Application for removal or variation of a condition following grant of planning permission. Town and Country Planning Act 1990. Planning (Listed Buildings and Conservation Areas) Act 1990

Development: Erection of a ground floor side/rear and first floor extension, including the construction of a rear dormer and installation of rooflights to facilitate the creation of habitable space within the loft and erection of front boundary wall and gates

6/2019/2591/HOUSE

introduce new condition 3 to be referenced to drawing plans " 760 -r(rev1)- 50 plough hill cuffley "

PROPOSED ROOF PLAN

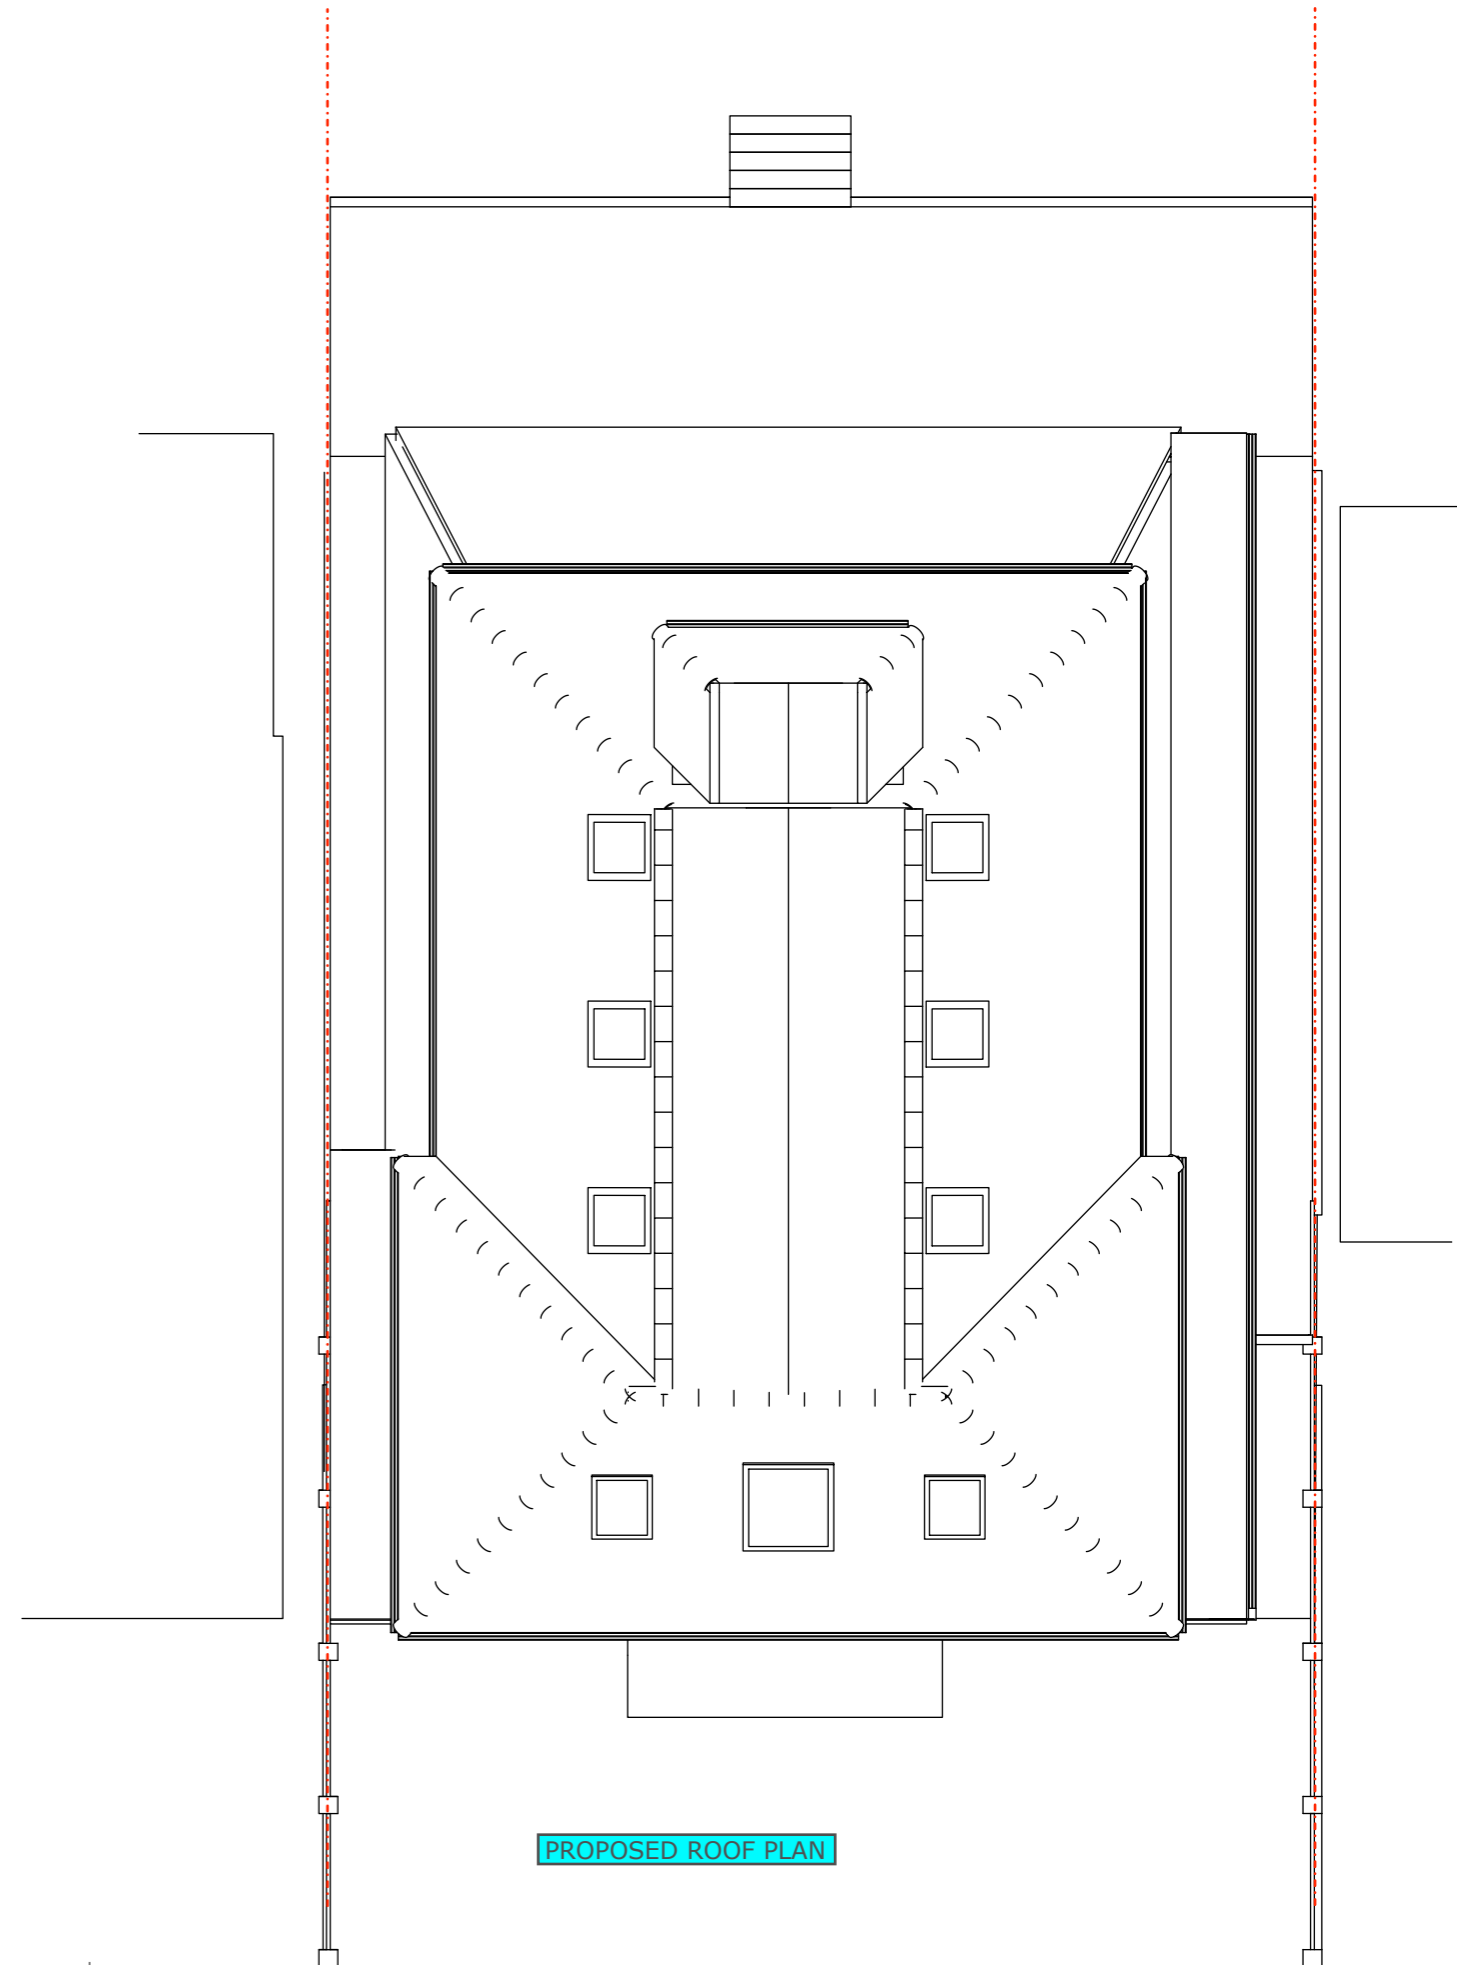
Design style change:-
Condition variation on plan of the window design on the front elevation to be central sash with side light panels (as seen on plans).
Materials selected of the roof to be Marley concrete smooth grey
